LANDSCAPE REPORT

43-45 BEANE STREET & 2
KEEVERS LANE,
GOSFORD, NSW 2250

LANDSCAPE CONCEPT PACKAGE

CITY OF GOSFORD DESIGN ADVISORY PANEL COMMENTS: LANDSCAPE

E-E SECTION E-E
1:125@A1 1:250@A3

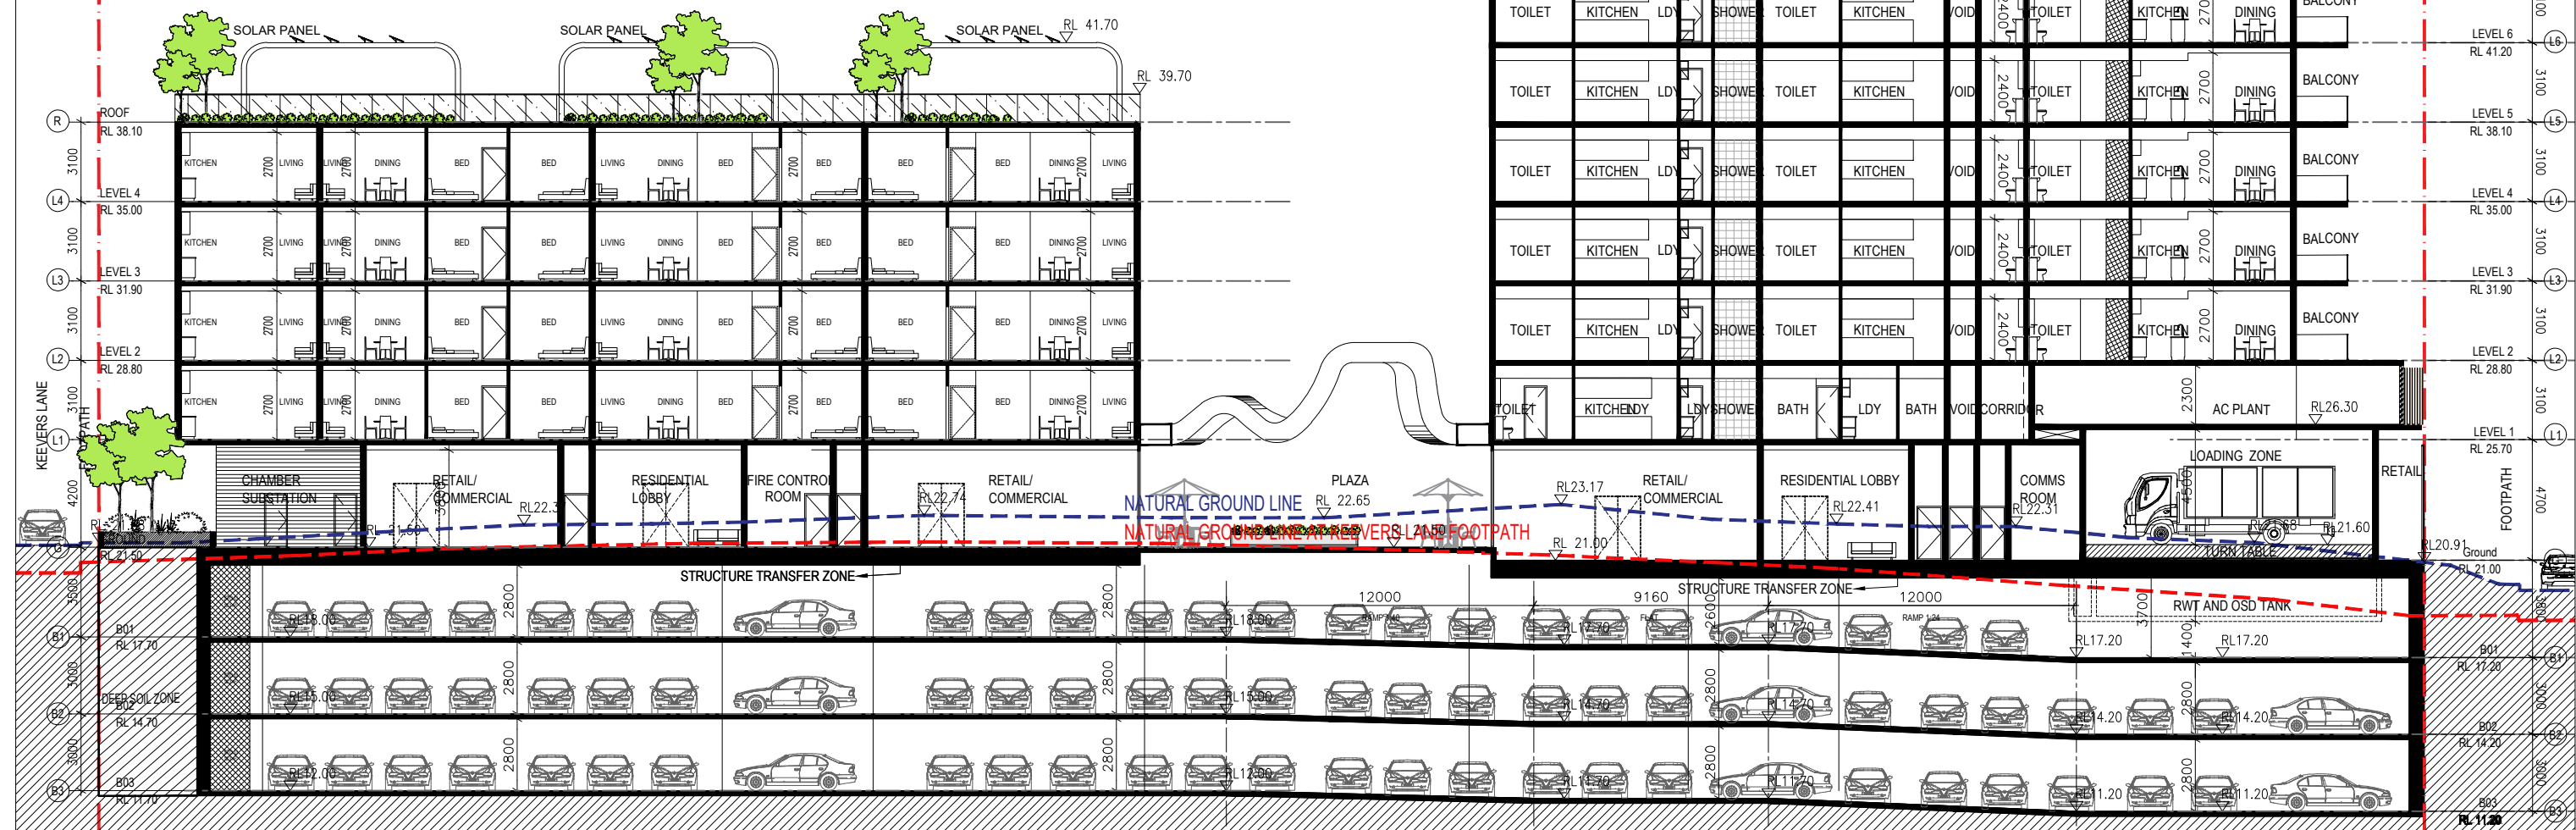
1. Tree Coordination with Architectural Elements

1.1 Interaction Between Tree Plantings & Proposed Built Form

As demonstrated in Section E-E and West Elevation on LP_05, tree pits and plantings along Keevers Lane have been strategically co-ordinated with the balcony and awning designs to ensure no conflicts arise. Specifically, shifting/sliding balconies at Level 1 and above create widened voids to accommodate the height and canopy spreads of the proposed tree species. Additionally, the ground floor awning extents narrow at the tree pit locations to ensure sufficient growing dimensions for the tree plantings. The proposed tree species mature heights of 8m (*Elaeocarpus eumundii*) and 10 metres (*Waterhousia floribunda* 'Sweeper') have been strategically coordinated with the architectural form to ensure clear space for the trees to develop vertically and laterally, establishing to their full dimensions with no requirement for ongoing pruning and no future building conflict.
